LU/94/12/AMA

Application for a non-material amendment following a grant of planning permission.

LOFT CONVERSION & CONSERVATORY - DECISION NOTICE ATTACHED

LU/336/11

SHEET 3 OF 6

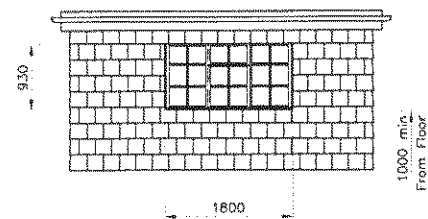
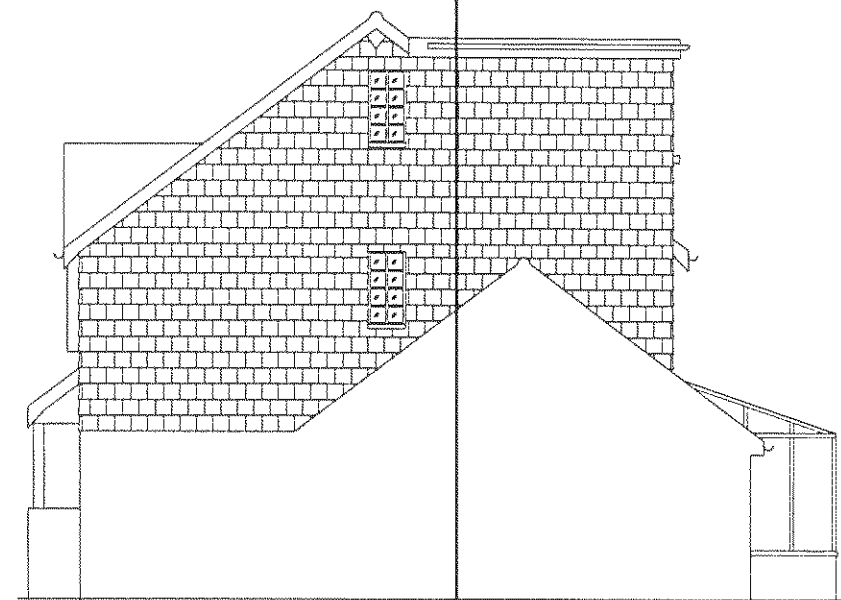
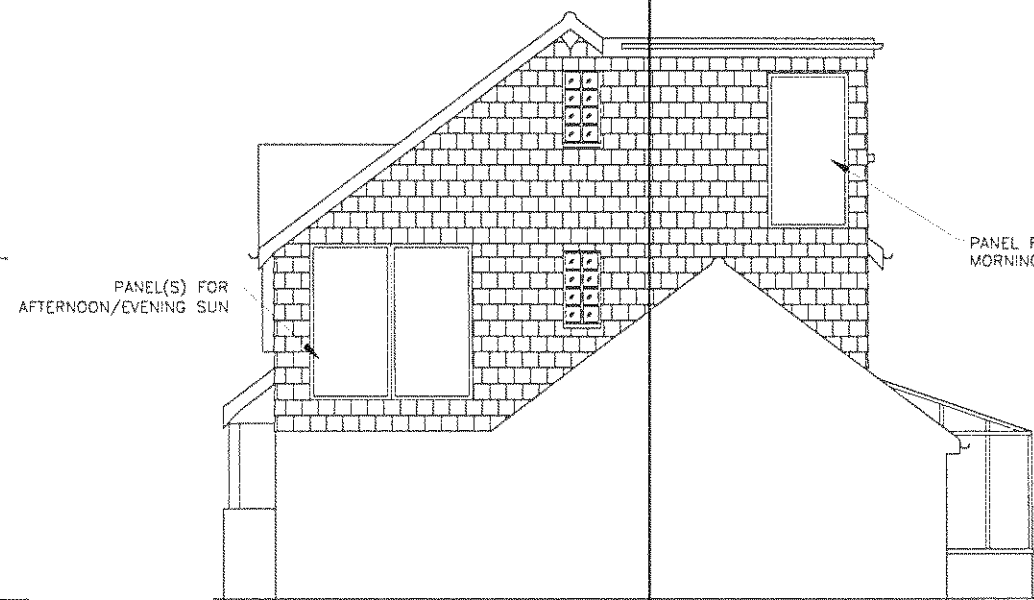
- 1) INCLUSION OF 2, 3 OR 4 SOLAR HEATING PANELS IN THE NEW TILE HUNG SOUTH FACING WALL. THE NUMBER/SIZE WILL BE DETERMINED BY THE MANUFACTURER. THEY WILL BE FLUSH FITTING WITHIN THE TILE HANGING SO NOT TO DETRACT FROM THE PROPERTY APPEARANCE.
- 2) CHANGE DORMER WINDOW (2 OFF) TO ONE CASEMENT/VENT/CASEMENT OF EQUAL SURFACE AREA, IN THE SAME STYLE AS CURRENTLY FITTED TO THE FRONT OF THE HOUSE.

BW029 ISSUE P3 SHTS 1 TO 6 - SHT 6 CONTAINS THE AMENDMENTS
